WEST SUSSEX COUNTY COUNCIL CONSULTATION

TO:	Arun District Council FAO: Amber Willard
FROM:	WSCC - Highways Authority
DATE:	23 June 2022
LOCATION:	82 Victoria Drive, Bognor Regis, PO21 2TA
SUBJECT:	BR/117/22/HH Erection of part first floor extension over existing ground floor including part two storey element to rear with Juliette balcony to front elevation, widening of drop kerb and replacement boundary wall.
DATE OF SITE VISIT:	N/A
RECOMMENDATION:	Advice
S106 CONTRIBUTION TOTAL:	N/A

Drawing:
**Existing and Proposed
Site Plan**

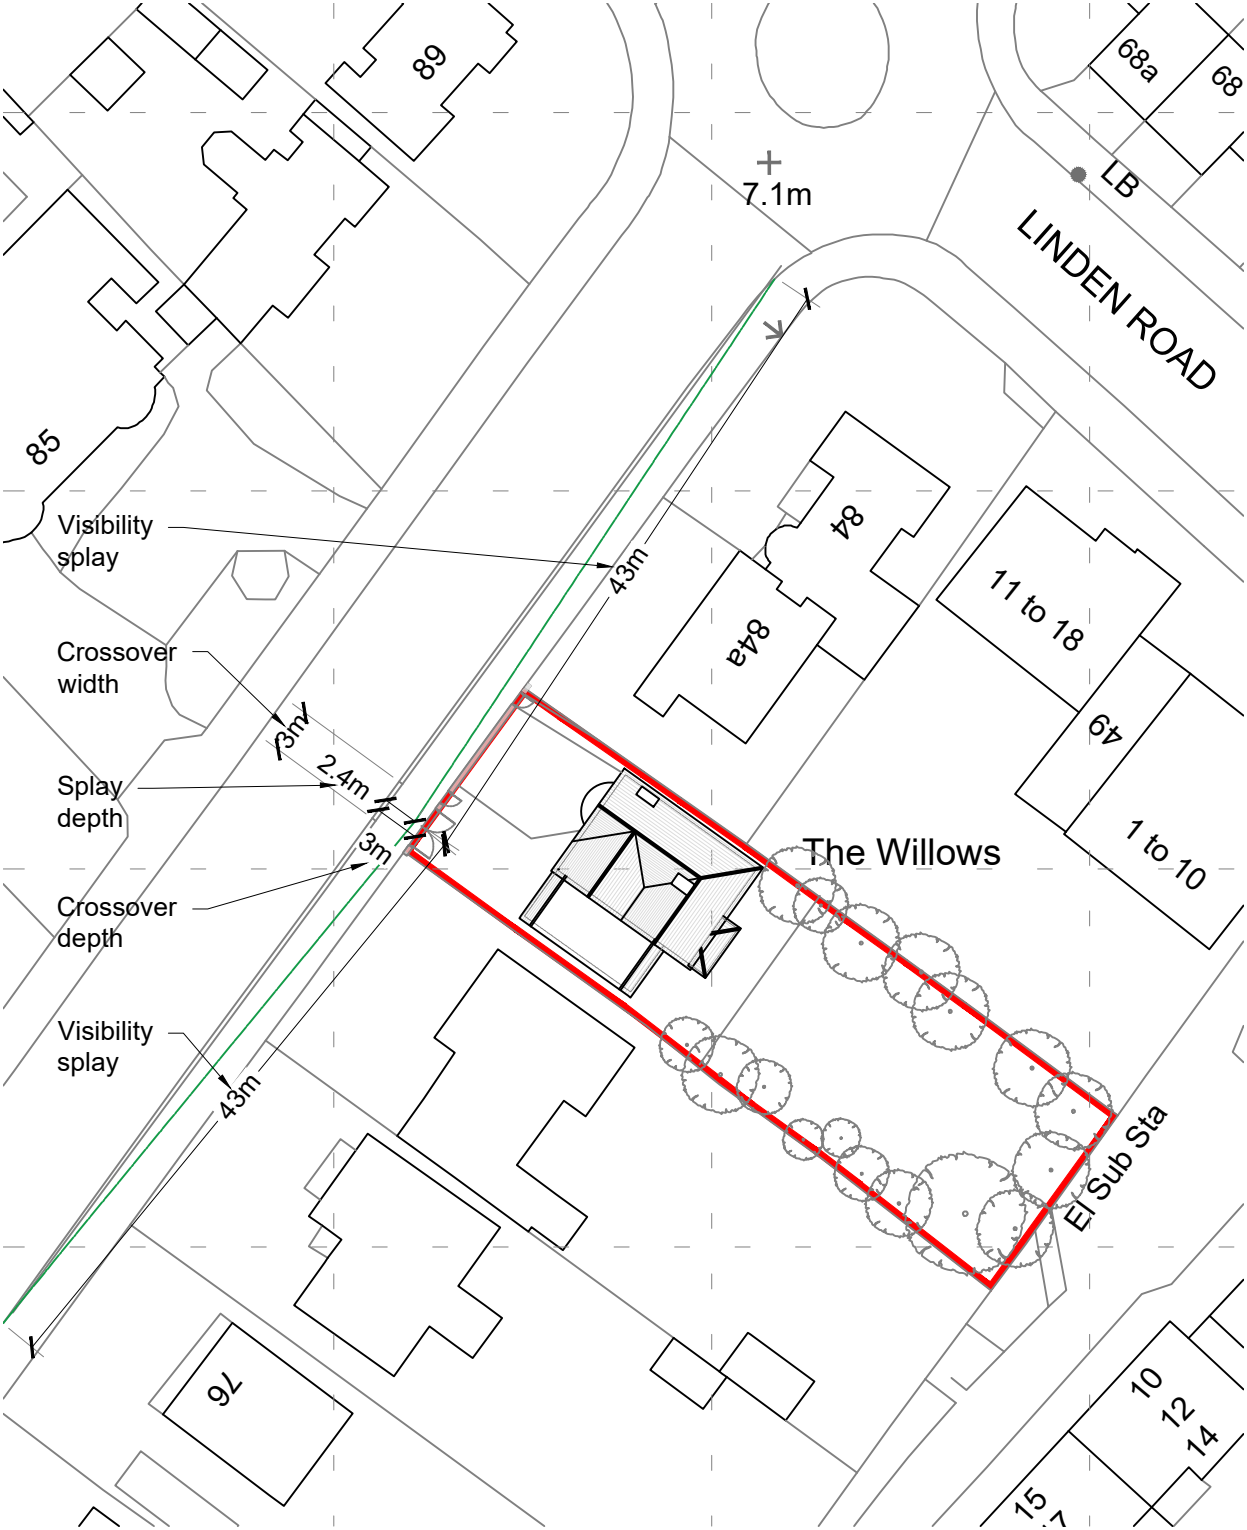
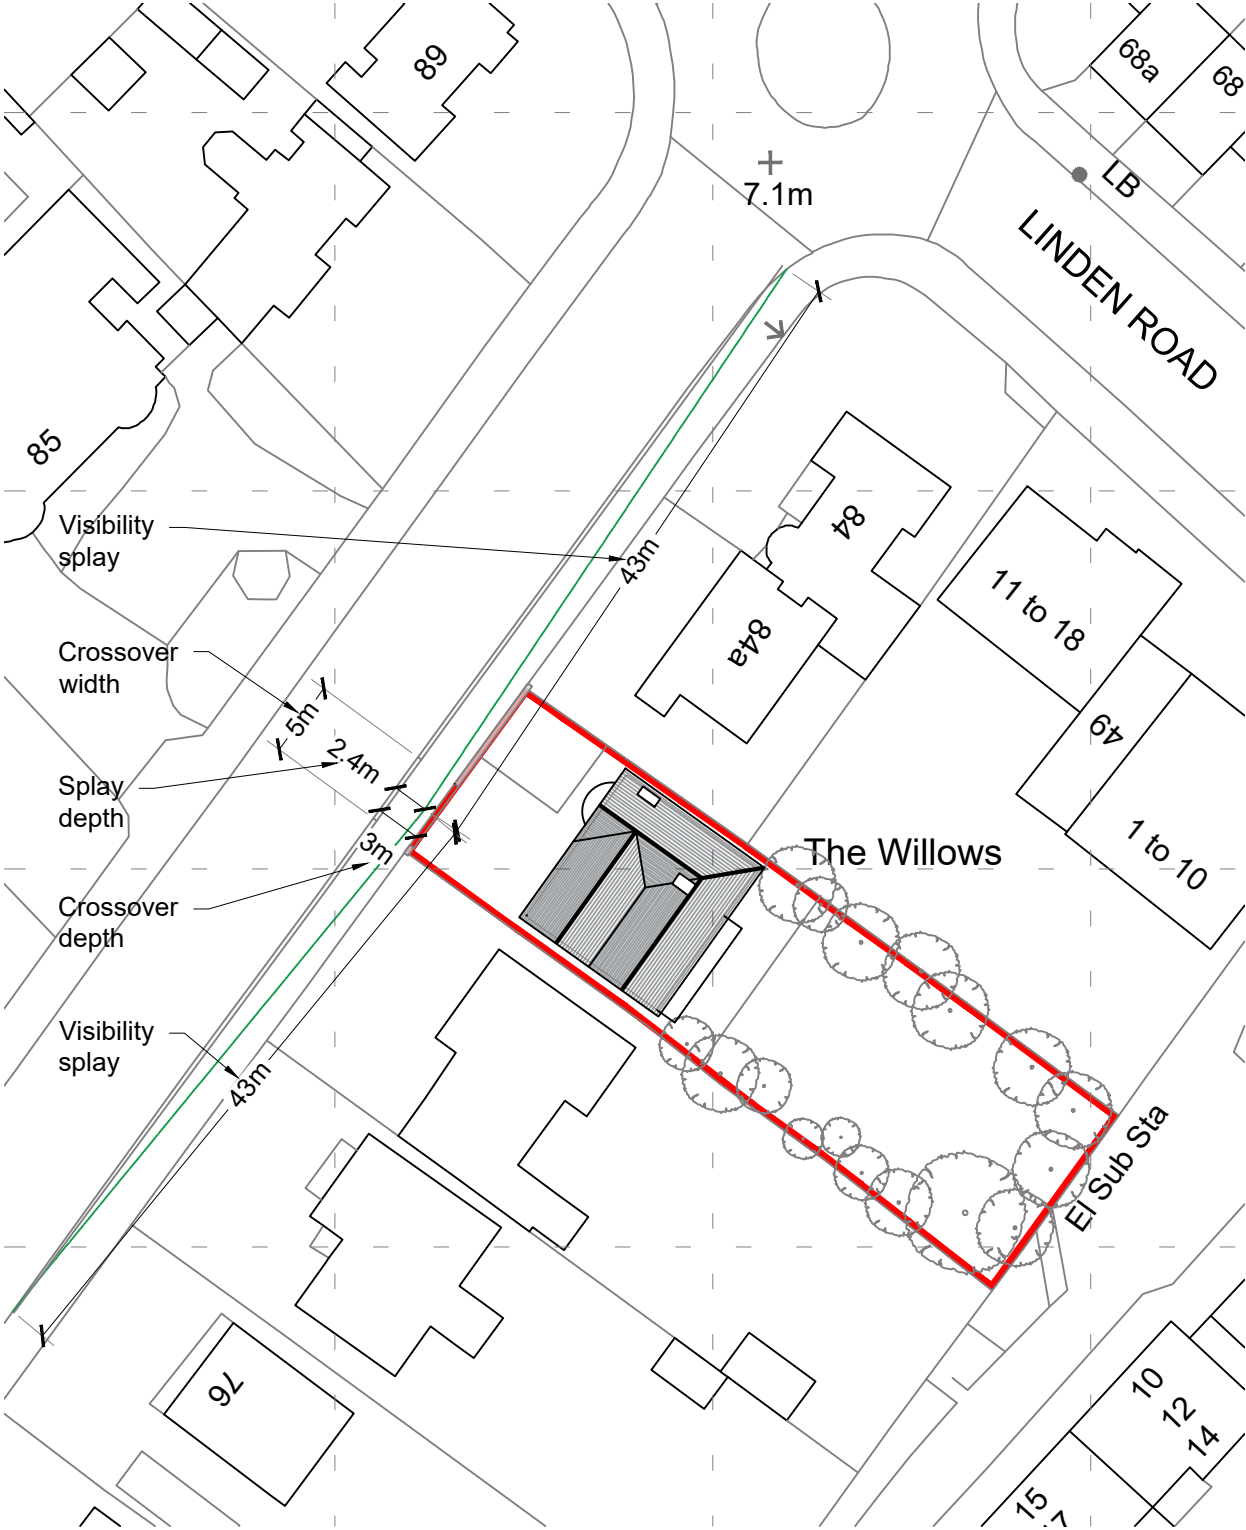
The applicant proposes a widening of the existing dropped kerb, to 5m. The proposed access works will be subject to a licence obtained through the local Highway Area Office and constructed to a specification agreed with the local Highway Area Engineer.

From inspection of local mapping, there are no apparent visibility issues with the existing point of access on to Victoria Drive. In addition, the LHA does not anticipate that the proposed development would give rise to a material intensification of movements to or from the site.

The proposed works will allow for a second off-street parking space. On-site turning does not appear achievable, so vehicles may have to exit the site in a reverse gear. However, this is the existing arrangement that has operated with no known safety concerns.
